From: Amanda Scholes on behalf of Planning.Responses
Sent: 13 April 2018 08:21
To: Planning Scanning
Subject: FW: Planning Consultation on LU/49/18/DOC

APPLICATION NO: LU/49/18/DOC

Registered: 15-MAR-18
Site Address: Land North of and South of Railway Courtwick Lane

Approval of details reserved by conditions imposed under planning approval LU/282/17/RES relating to Conditions(s)
Condition 3: Details of the Materials and External Finishes,
Condition 4: A Detailed Level Survey

Drawing Number			Rev.	
4485/3071			F

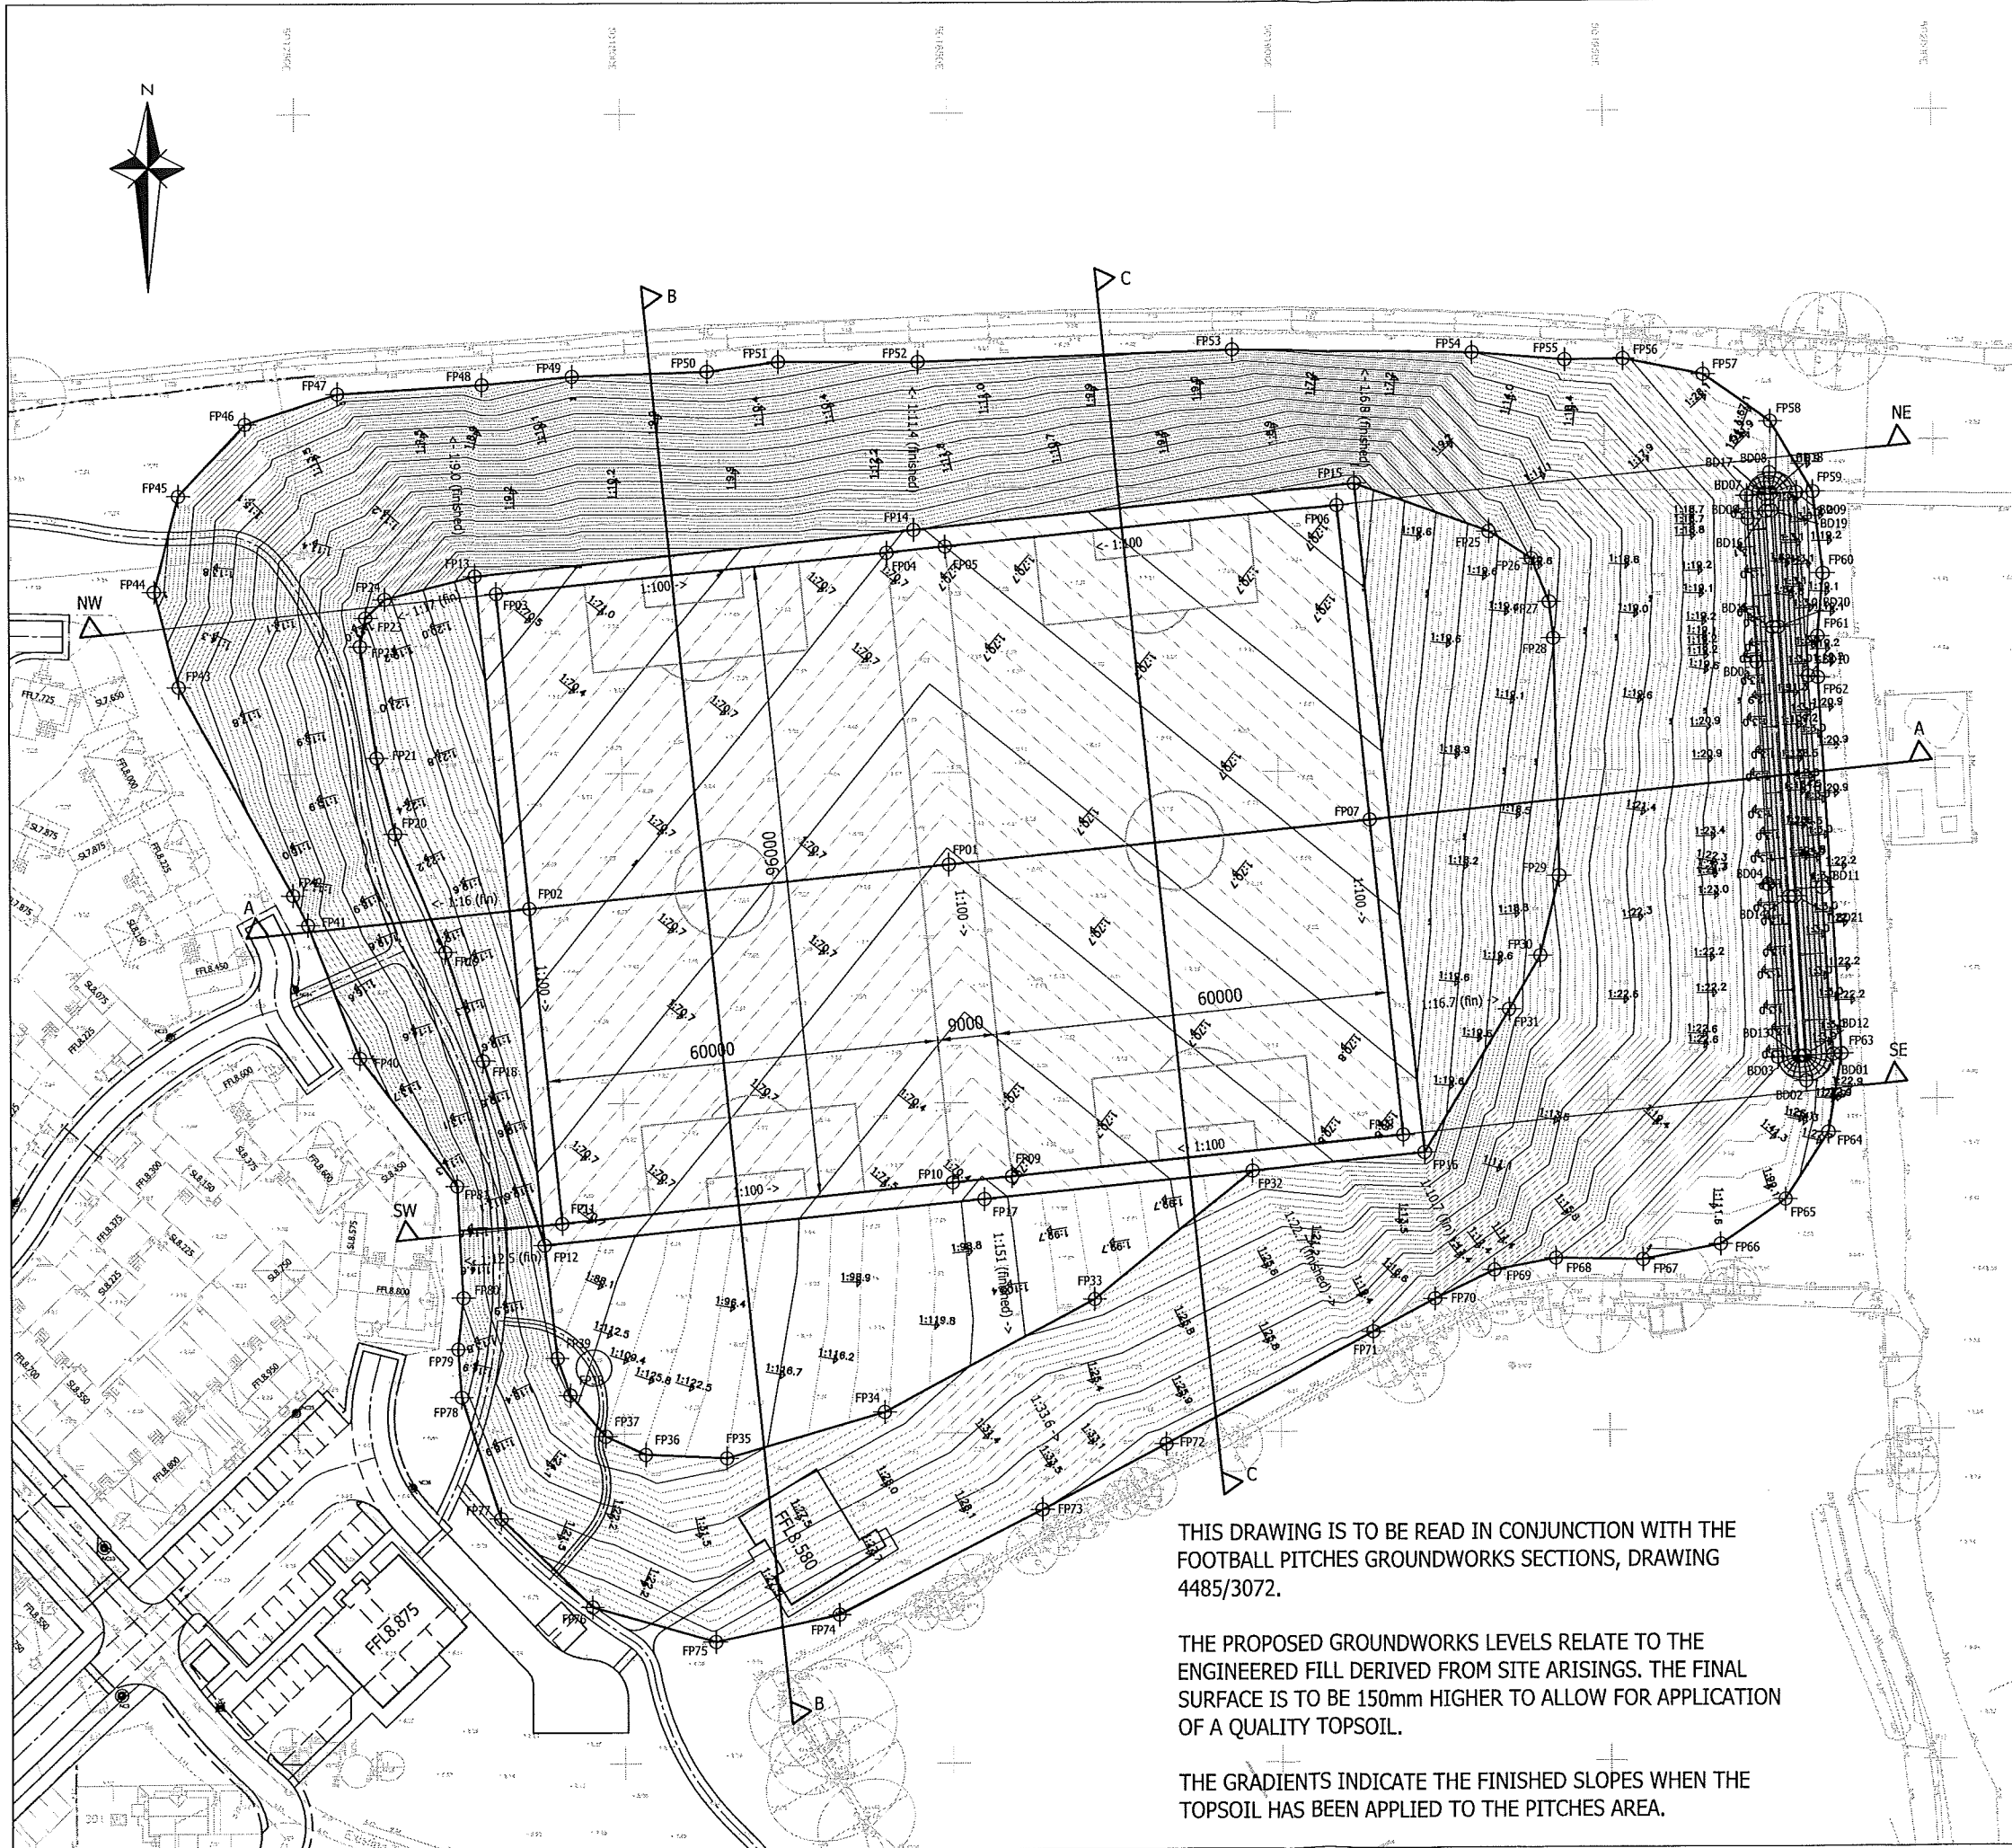
Drainage from the site needs to be controlled to ensure no detriment is caused to surrounding land and properties. Currently the plans show no way of controlling run off from the site. We recommend this is reviewed, and drainage is included around the perimeter and that the proposed changing facilities also have drainage around them to ensure that surface water does not flow off of the pitches and through them.
If the applicant requires any advice it is recommended that they contact us.
